Consultation Response from: KC Environmental Health (Pollution & Noise Control)

2024/92016 - Land Adjacent, The Shears, 201, Halifax Road, Hightown, Liversedge, WF15 6NR

Discharge of details reserved by conditions 5 (materials), 6 (boundary treatment), 7 (Phase I Desk Top Study), 12 (bin storage/locations), 13 (evc) on previous permission 2023/93657 for erection of two detached dwellings with detached garages; alterations to public house with dwelling above to form one dwelling; erection of single and two storey extension to 201a Halifax Road

Date Responded:
31st July 2024

Drawing No.
3571 (0-) 15

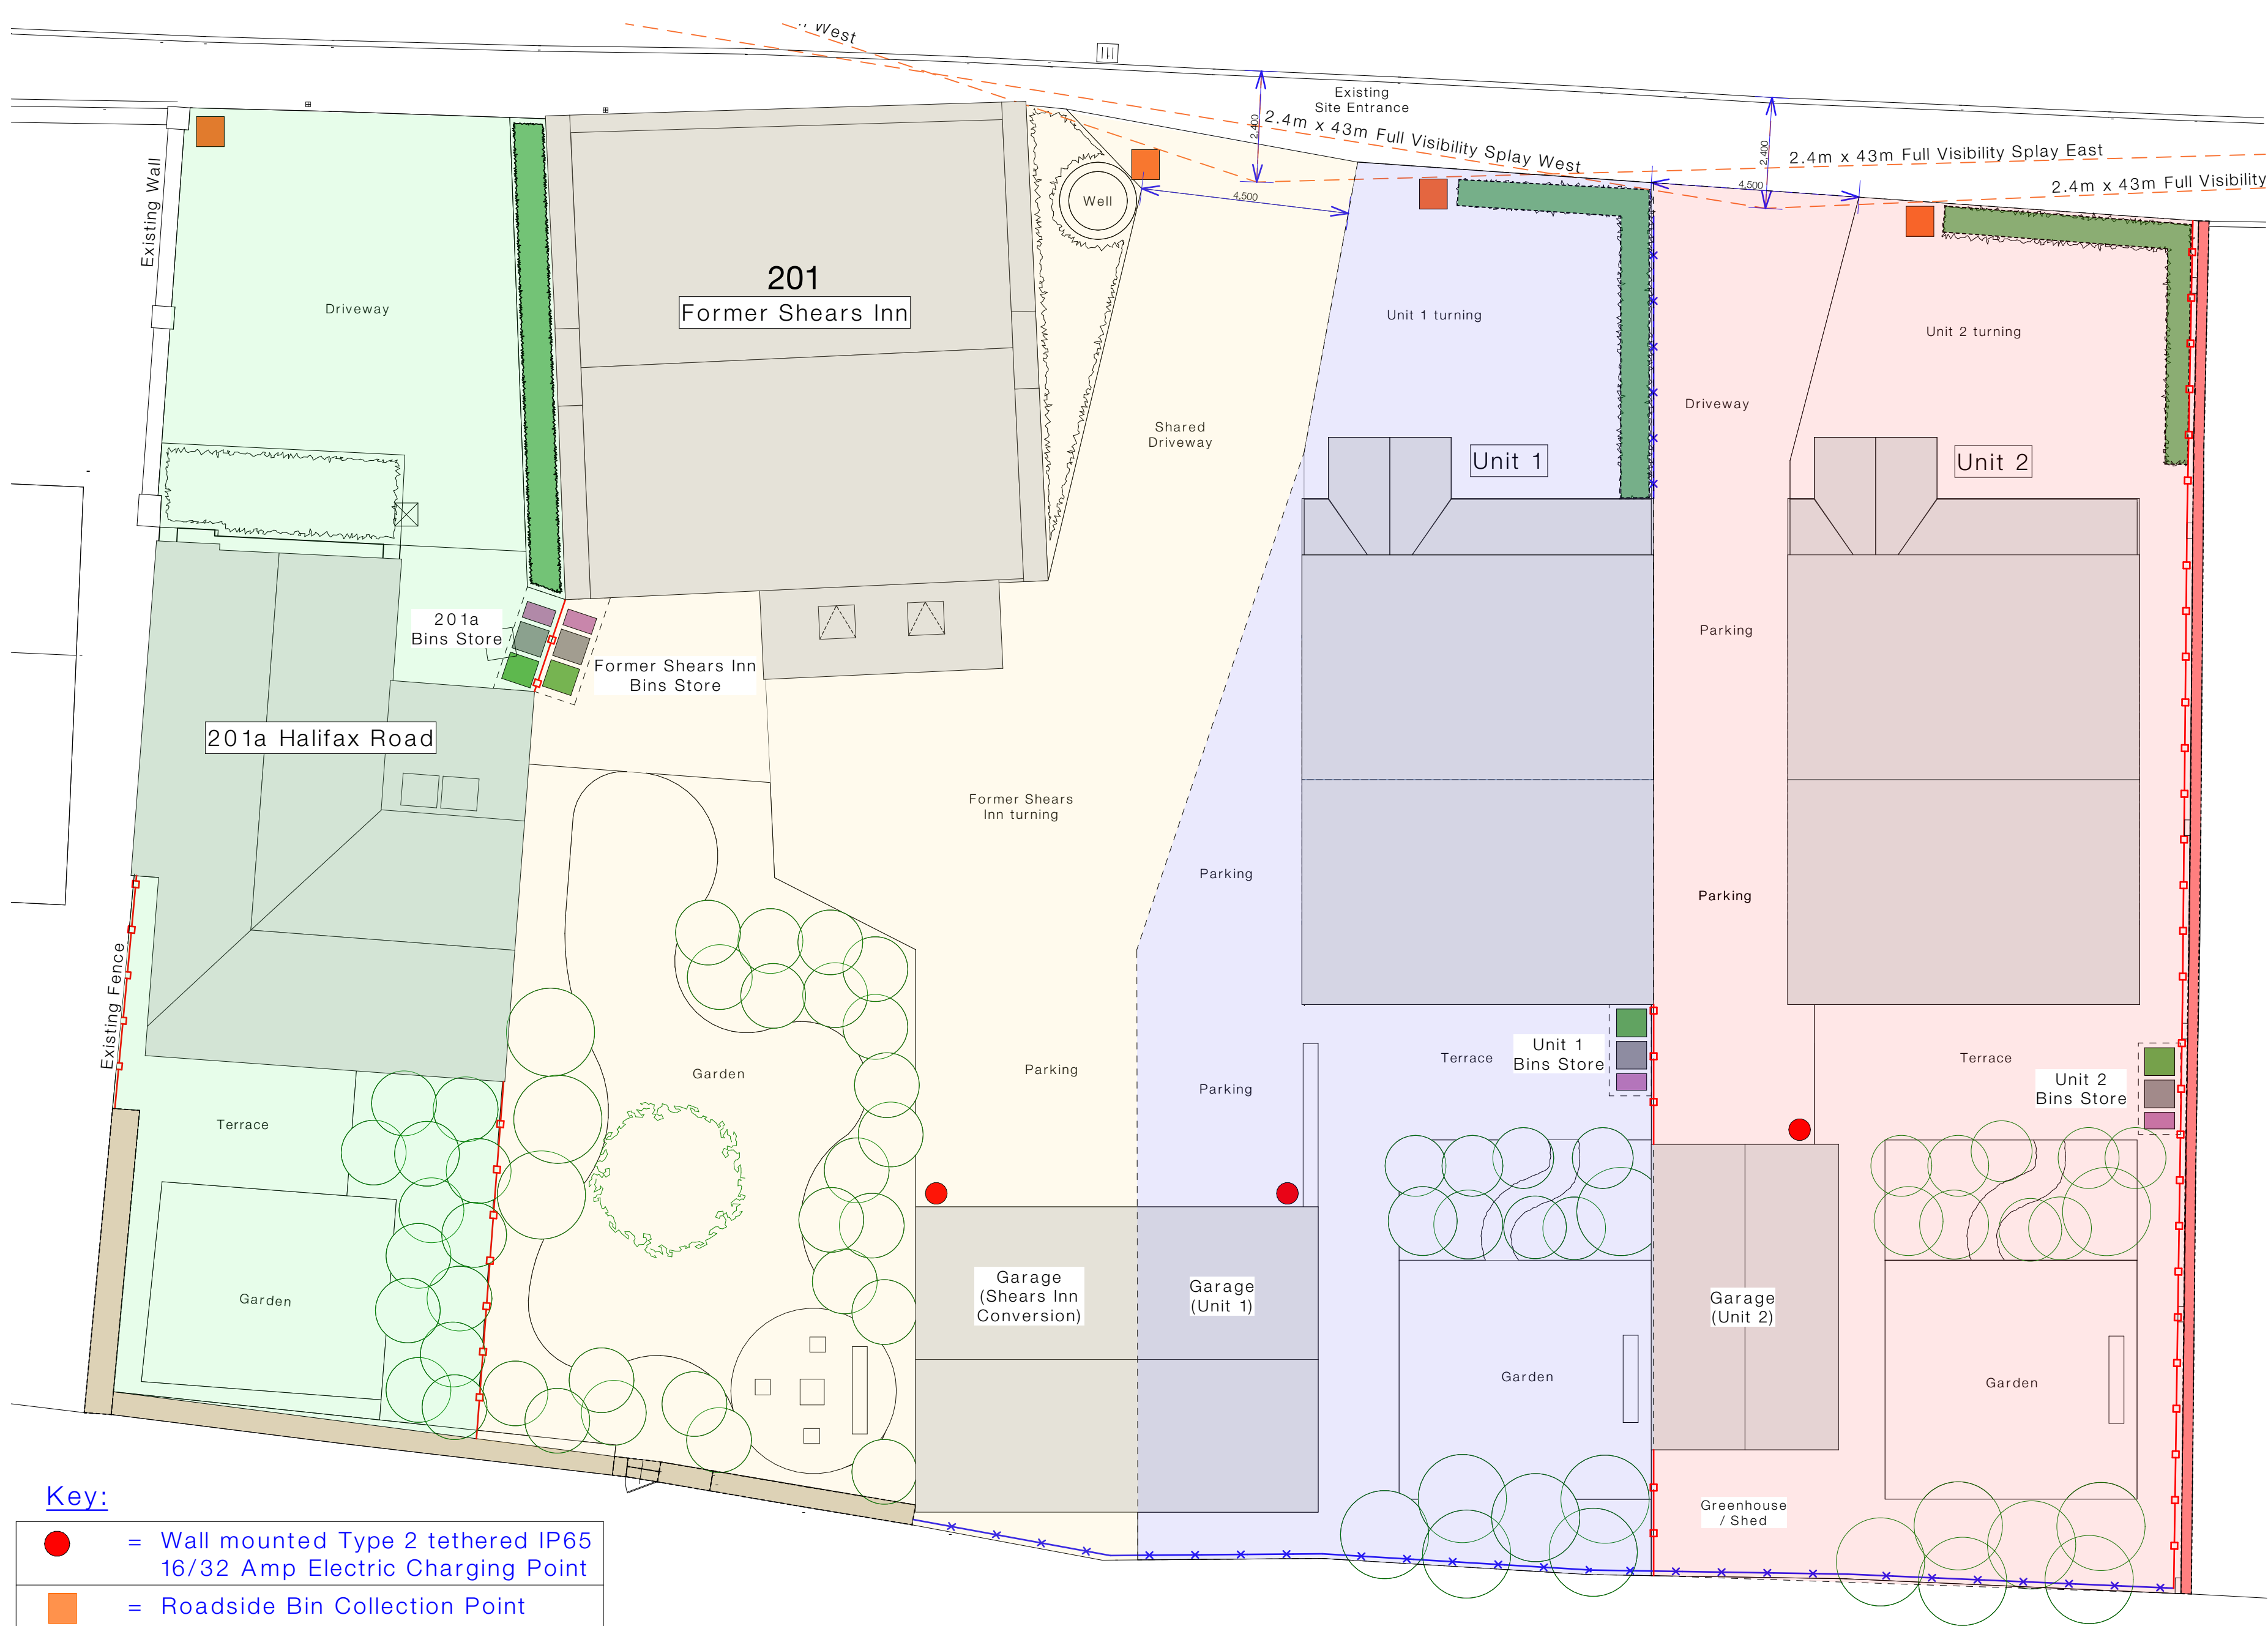
Drawing no 3571 (0-) 15 has been received in support of the application to discharge Condition 13. The plan proposes the installation of 1x wall mounted Type 2 32kw EVCP at each dwelling. The information above is acknowledged and accepted, however as the EVCPs have not yet been installed and need to be retained to comply with the condition, we recommend the condition remain in perpetuity.

We accept the proposals for the EVCP given in documents provided. As the EVCPs have not yet been installed and need to be retained to comply with the condition, we recommend the condition remain in perpetuity. Approval under the Building Regulations may also be required, and the applicant should contact their Building Control Provider for further information in relation to Approved Document S.
